**Consultation Response from KC,
Lead Local Flood Authority**

2025/93057 Land off, Hermitage Park, Lepton, Huddersfield, HD8 0JU

Discharge of details reserved by conditions 27 (BEMP) , 28 (swale), 29 (surface water) and 30 (storm modelling) of previous permission 2025/90105 for variation of conditions 6 (PROW), 9 (boundary treatment), 38 (bin collection), 40 (car parking) and 41 (access) of previous outline permission 2022/91735 (with access and layout) for erection of 80 dwellings and associated works

Date Responded: 3rd December 2025

ATTENUATION BASIN DETAILS
BASIN 2

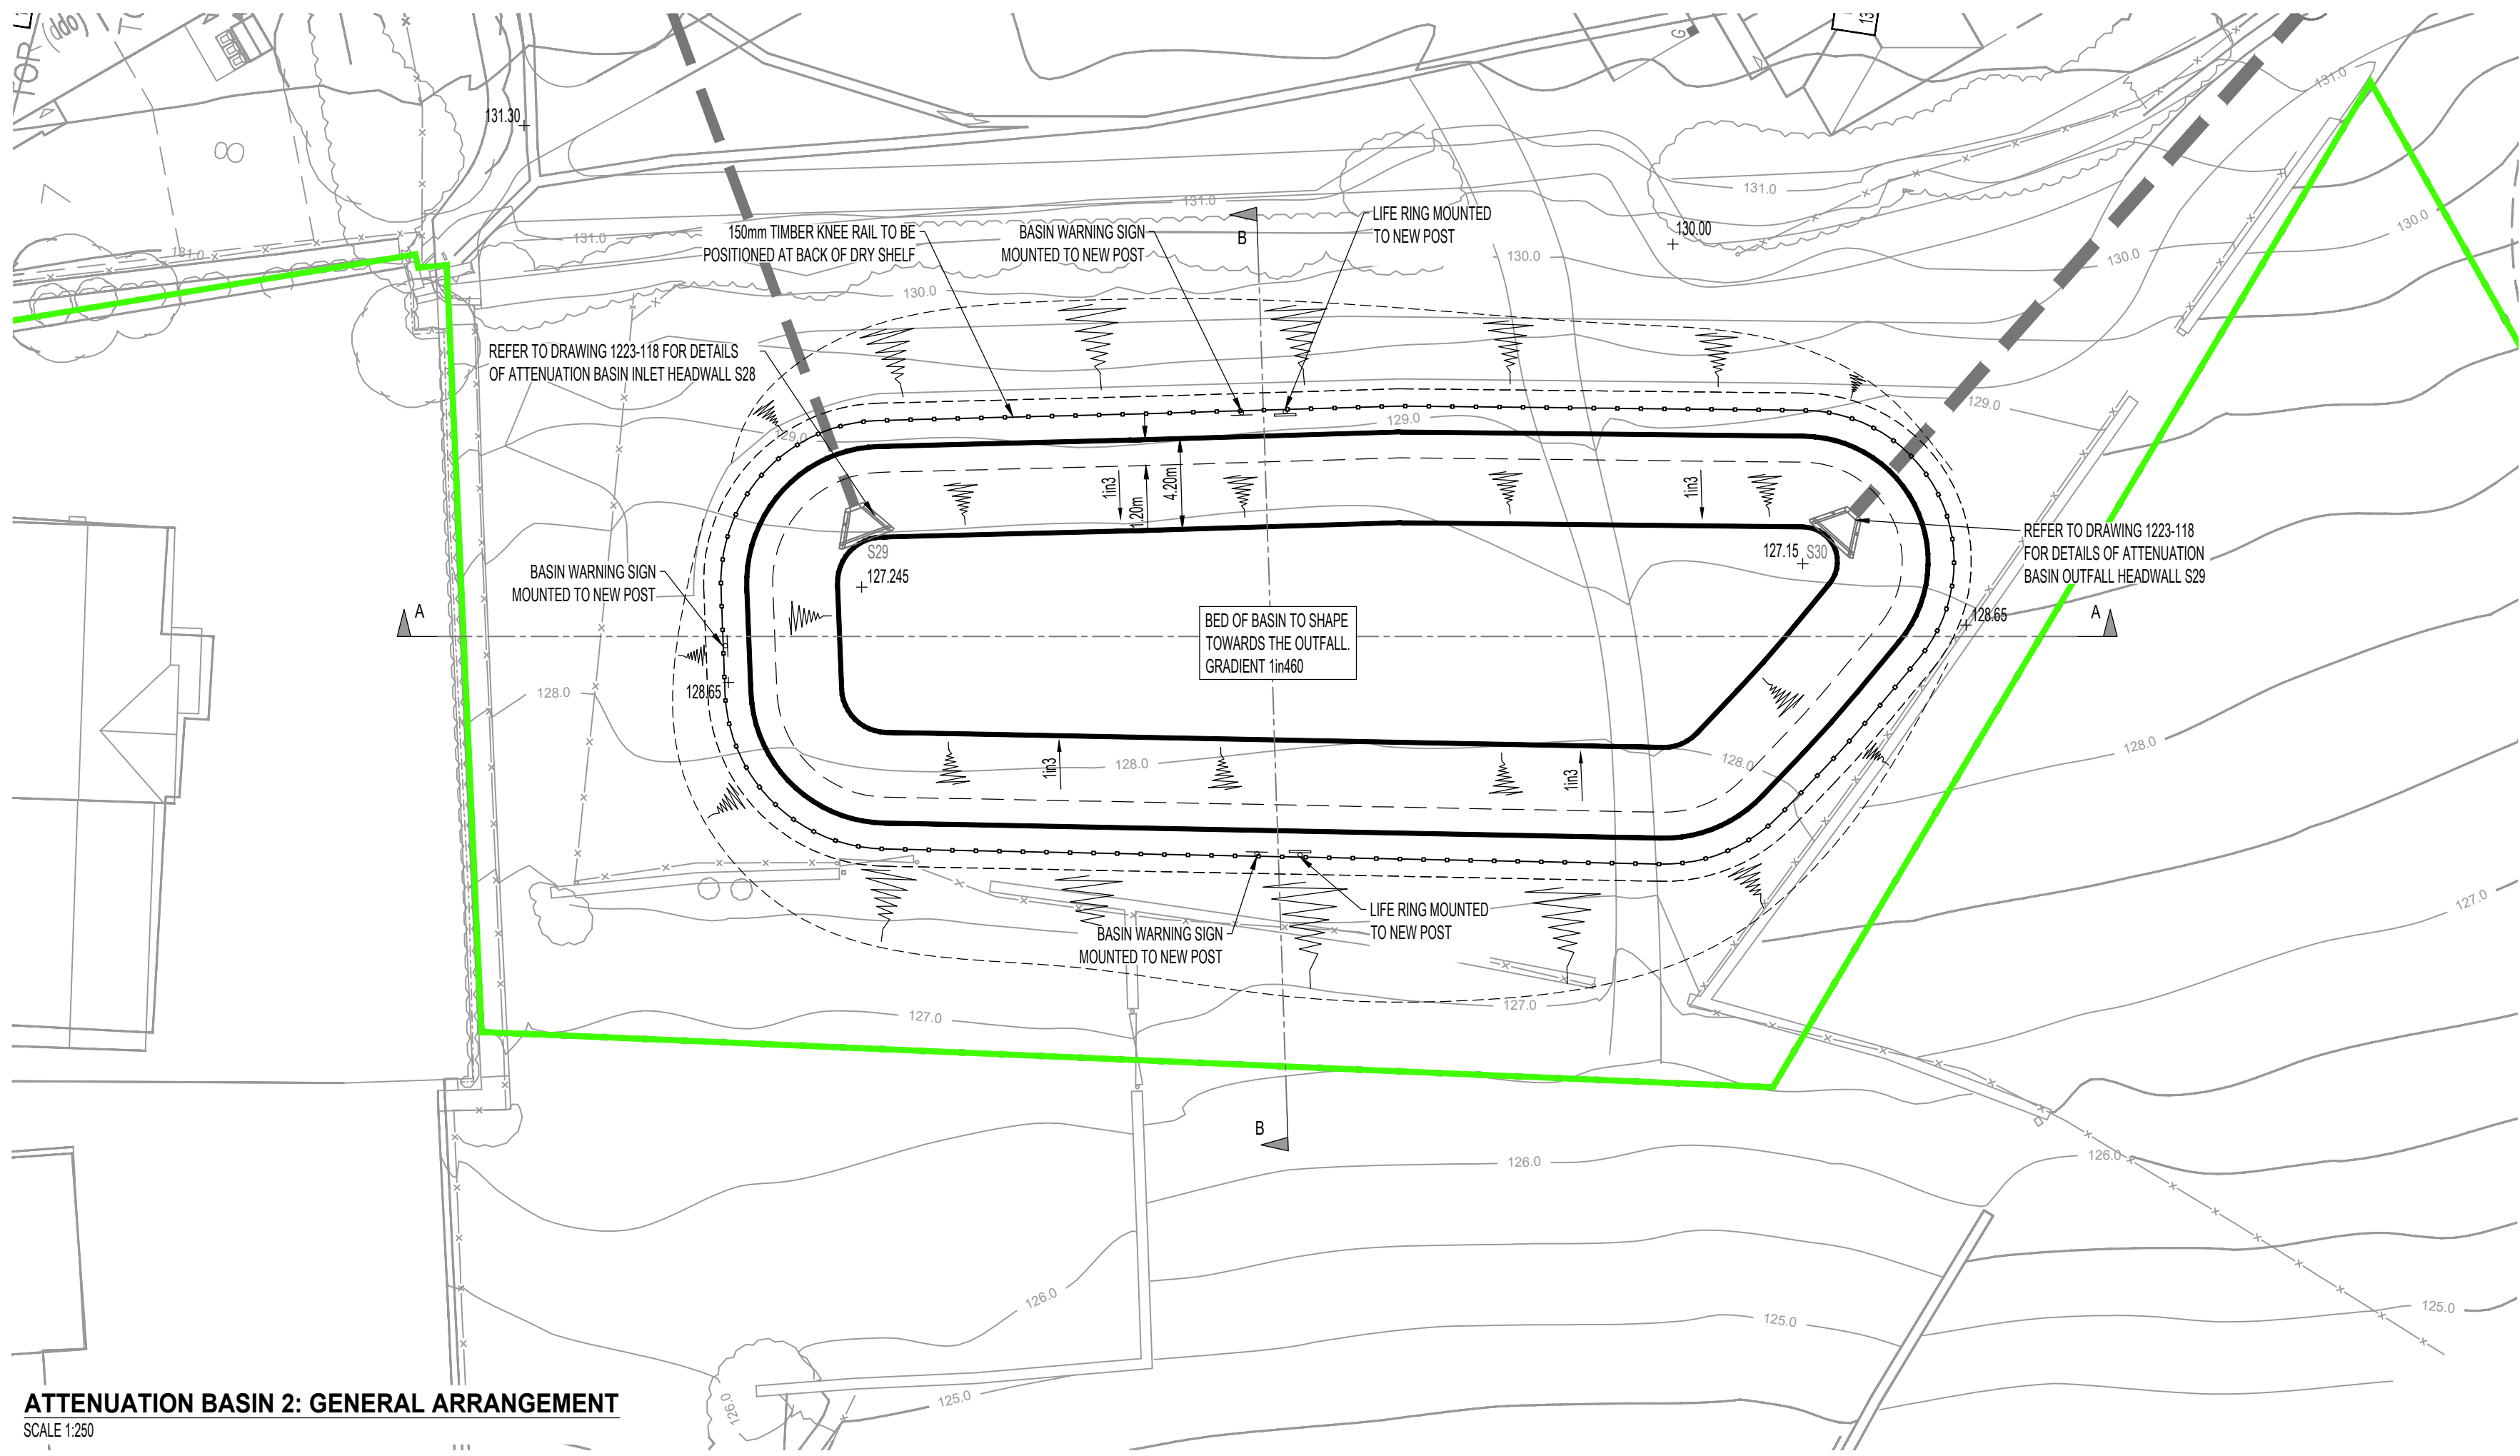
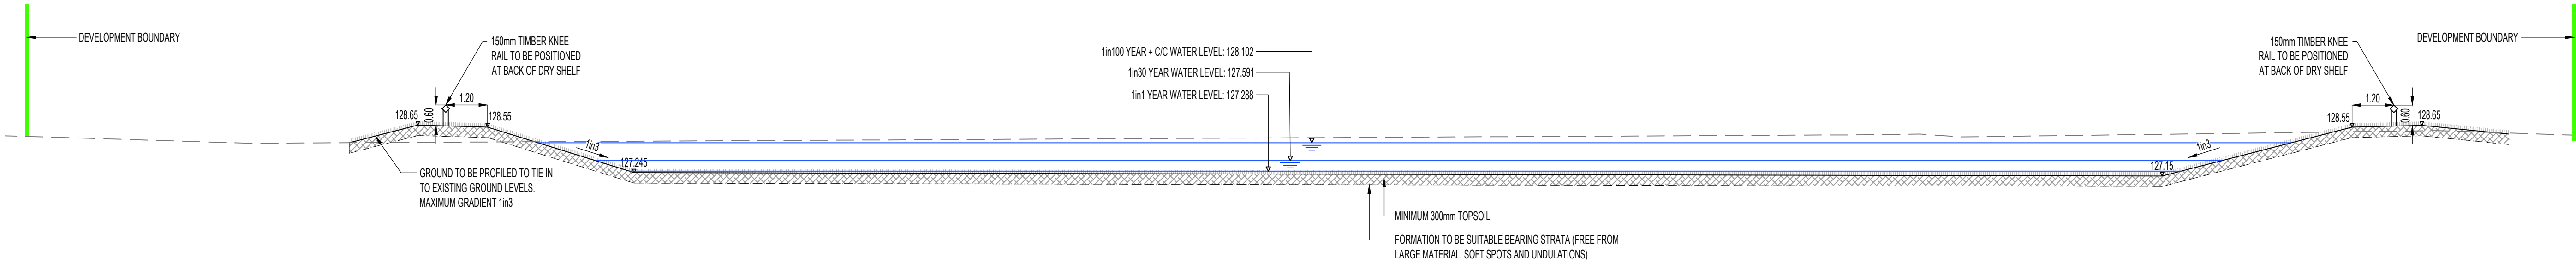
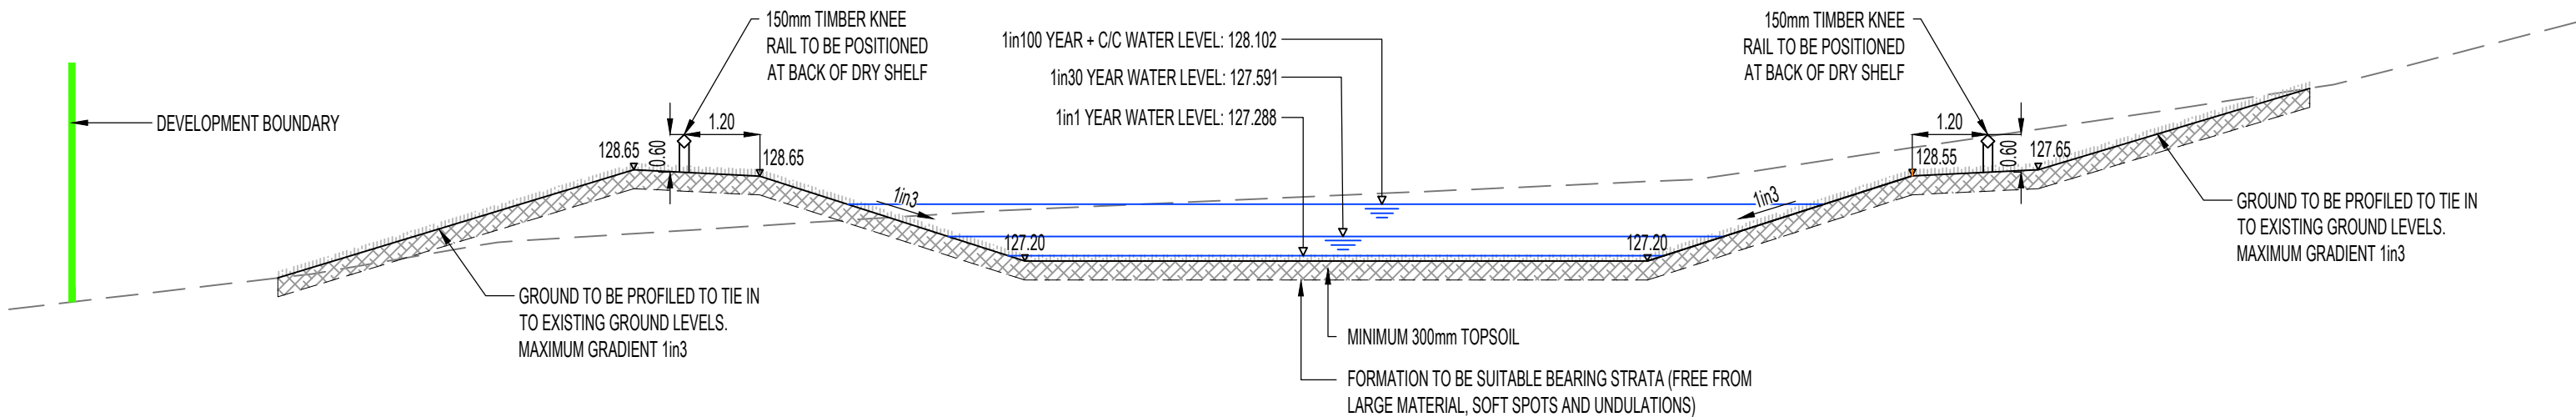
Basins are shown at 1 in 3 slopes and less than 1m of water in storm conditions. Measurements of length/width at the top and bottom should correspond to any basin data entered into a storm wizard on an appropriate hydraulic model.
